Written Representation to the Relevant Representation from Friends of Little Eaton Canal

Question by Examining Authority to FLEC in document Draft Consent Order and other consents permits and licences.

Non designated sites of interest: Question as per page 57, 8.13:

FIGURE 2.12F ENVIRONMENTAL MASTERPLAN (LITTLE EATON JUNCTION)

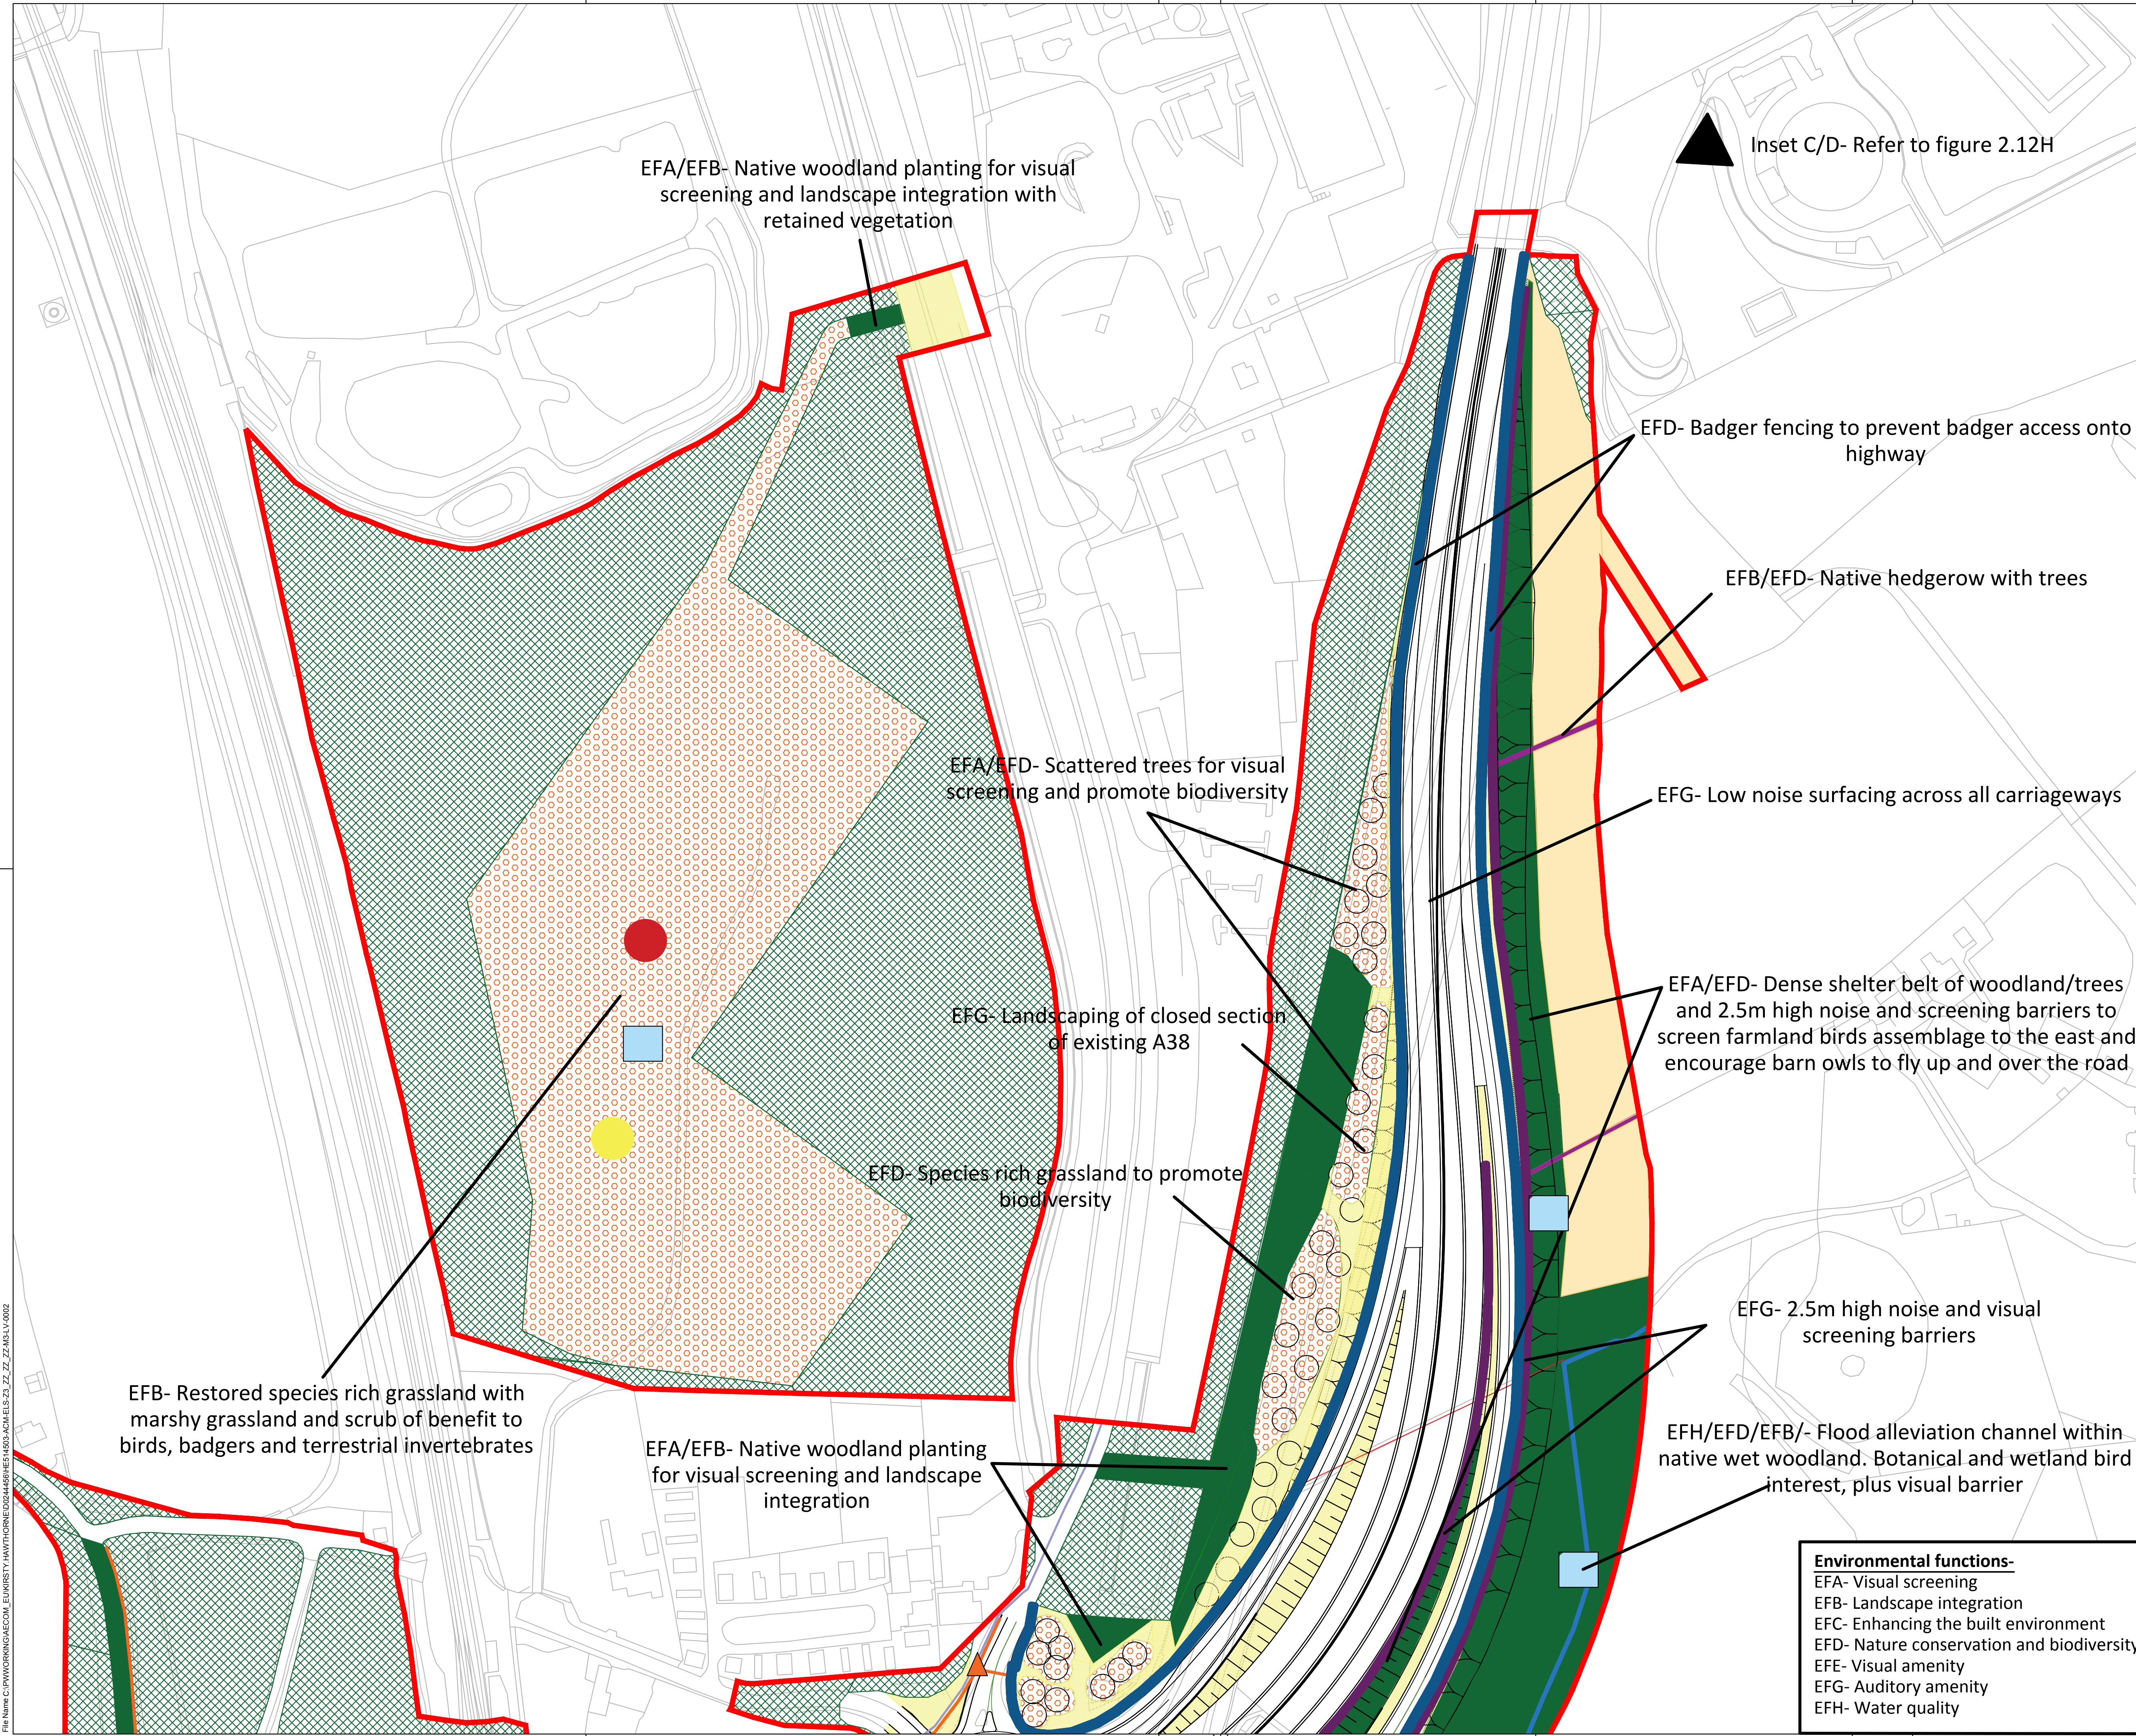
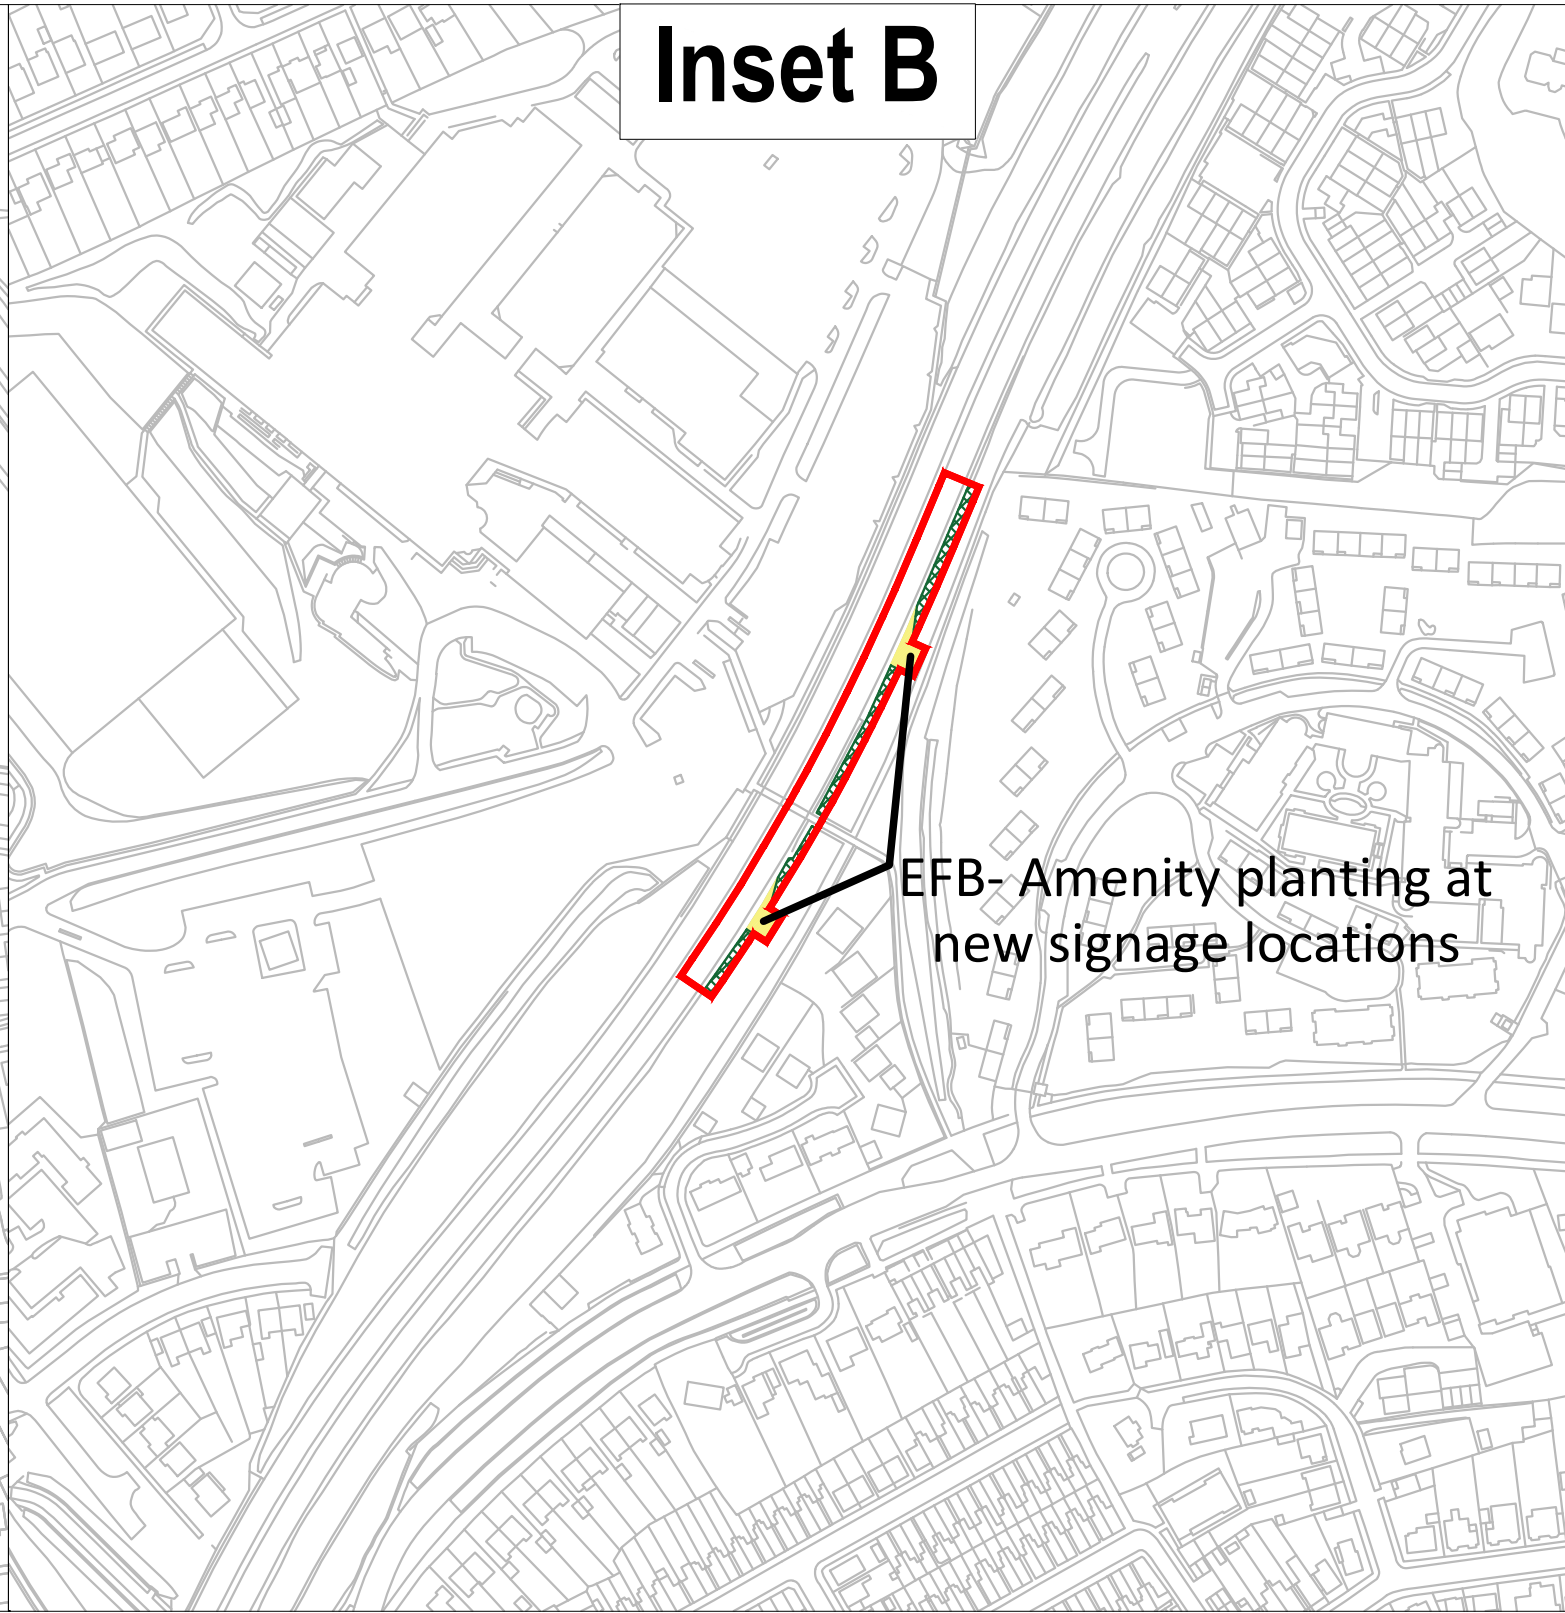
It is noted that “the foundations of such a bridge will be set back from the edge of the line of the former canal to avoid impacting on the existing vegetation and the canal profile and the affected footprint area being reinstated to their former conditions”. This does address some of FLEC’s concerns.

Our outstanding concern is related to the fact that the canal is enclosed by shrubs and trees to its east and west side. So, to further minimise ecological harm we would also seek reassurances that any shrub and tree removal to accommodate the actual bridge, as opposed to just the foundations, are also included in the reinstatement of the area after the bridge is removed.
